Ribble Valley Borough Council
Housing & Development Control

Application no: **3/2022/0500**

Address: **Land to the south of Chatburn Old Road Chatburn**

Proposal: **Technical Details Consent for residential development of upto 9 dwellings following Permission in Principle application 3/2018/0582 and appeal APP/T2350/W/19/3223816.**

project	moorend	project number	1903	drawing number	PL 51
name	site sections 2 of 2				
scale	1 to 200 @ A1	date	august 2020	status	planning
revision					A

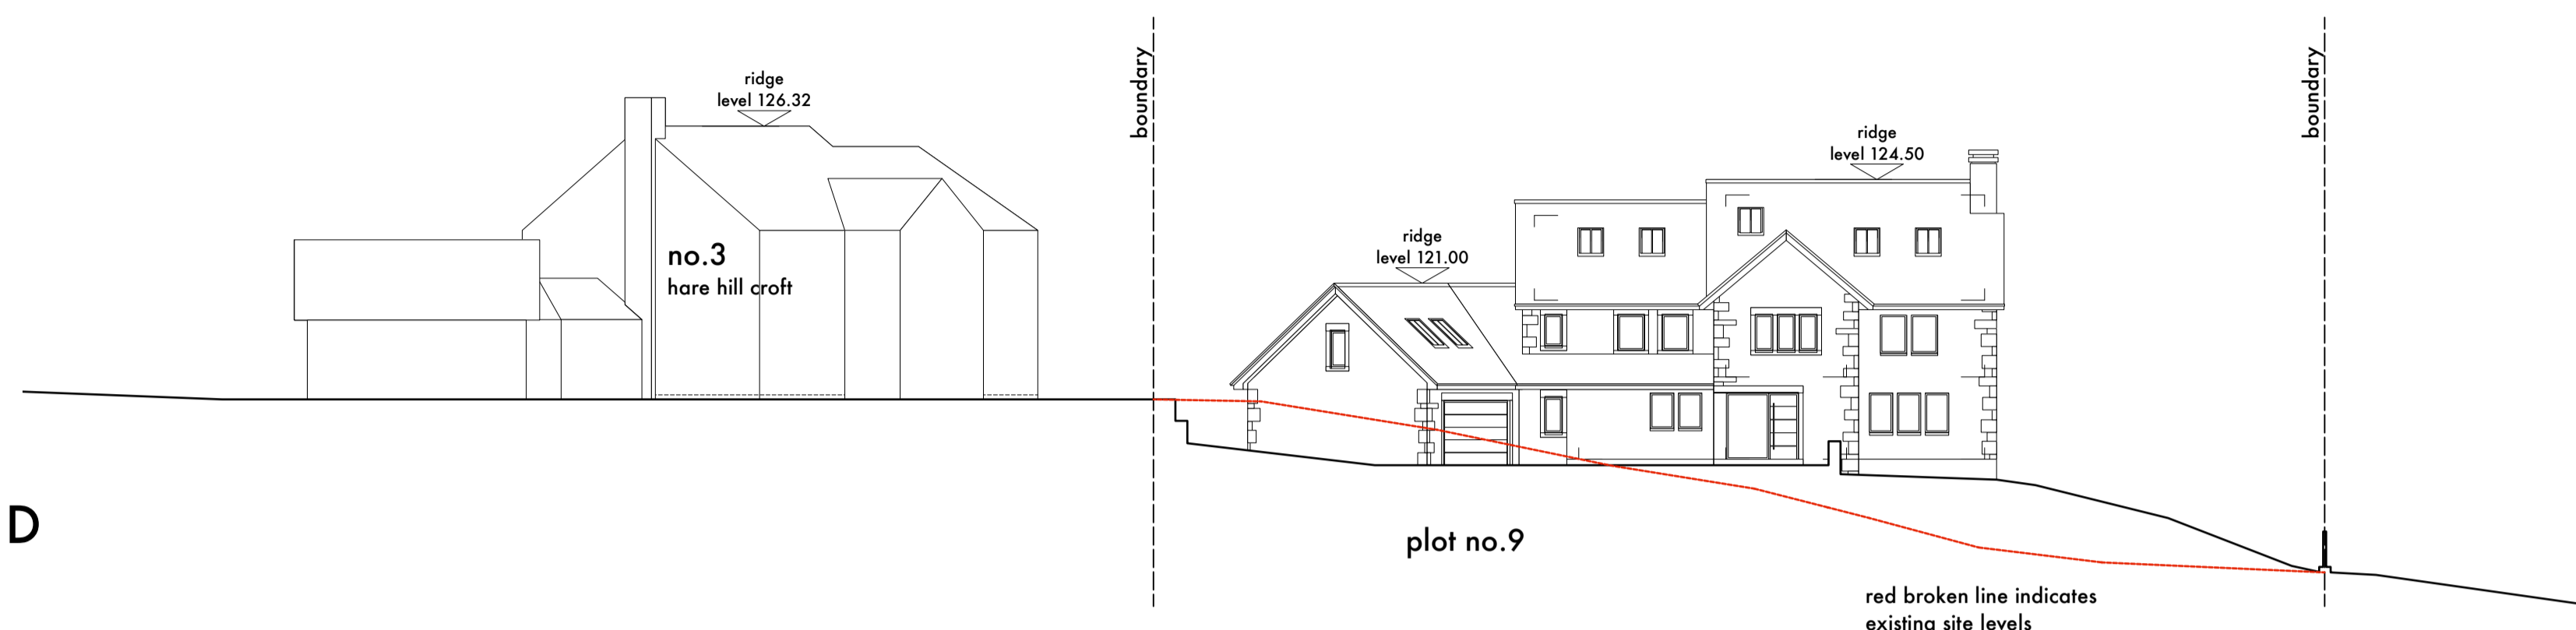
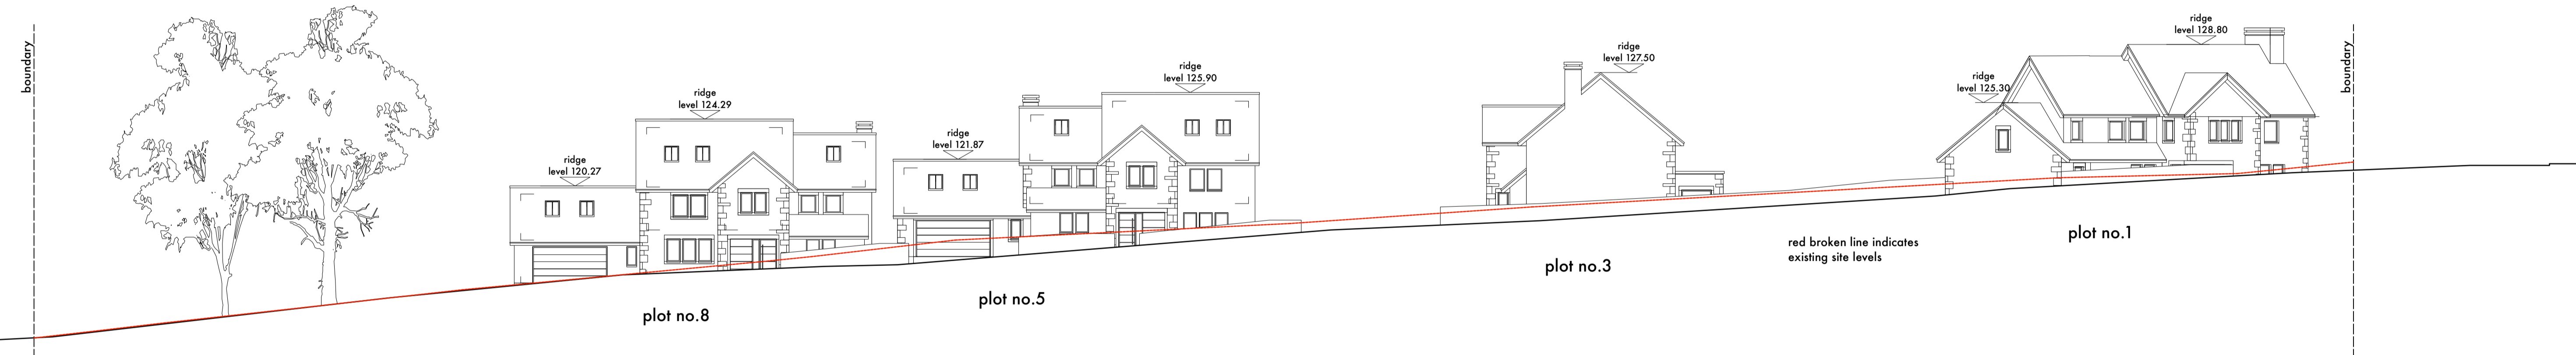
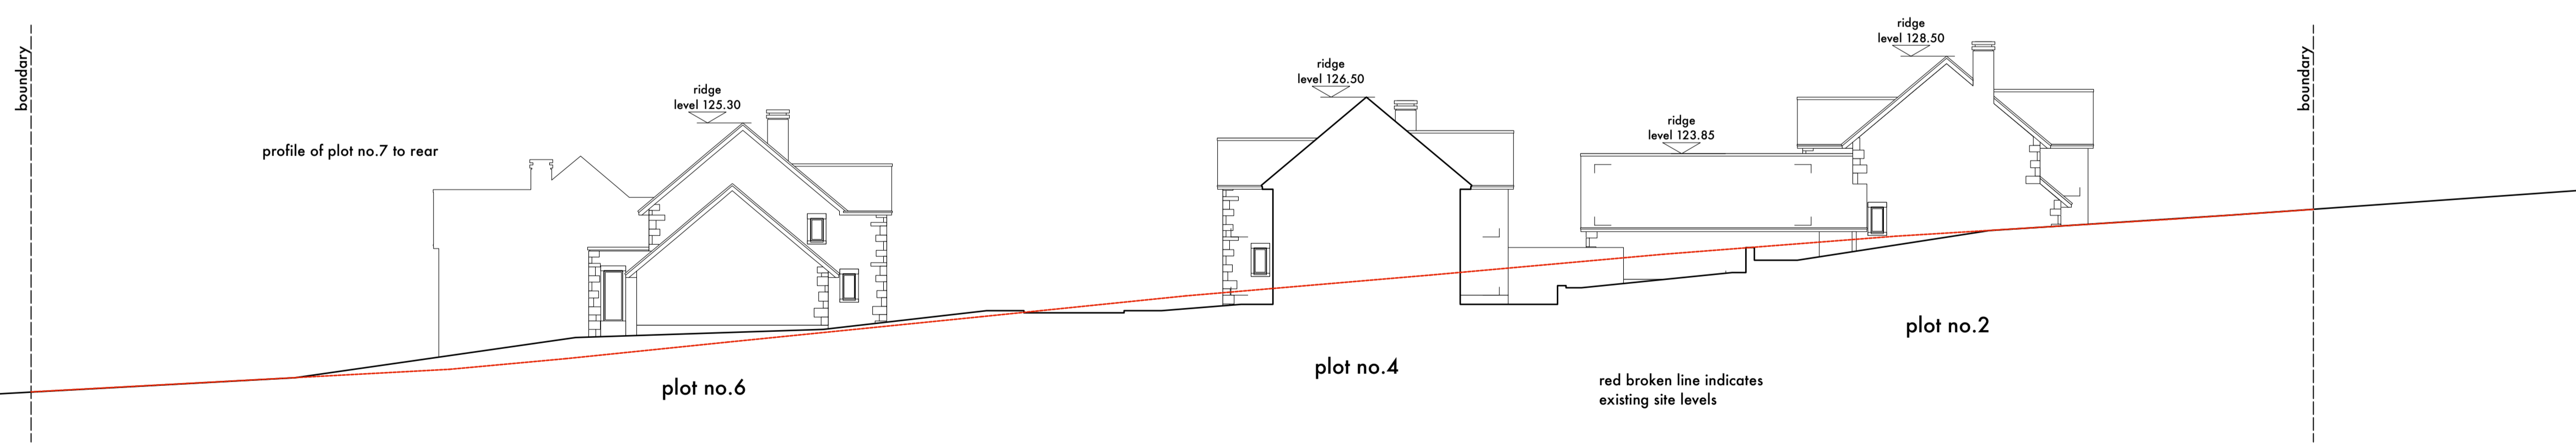
The LHA have also reviewed the site section and long section drawings of the access and the internal carriageway and are satisfied that the gradient throughout the site complies with the LHAs guidance.

The LHA will condition that a boundary treatment plan is submitted. This is because the LHA are aware that the embankment to the left of the access may require a retaining wall feature to be erected due to the level difference of the internal carriageway and the embankment.

The LHA will also require a site section drawing of the embankment, retaining wall and the carriageway to be conditioned to ensure that the gradient does not exceed 1 in 3.
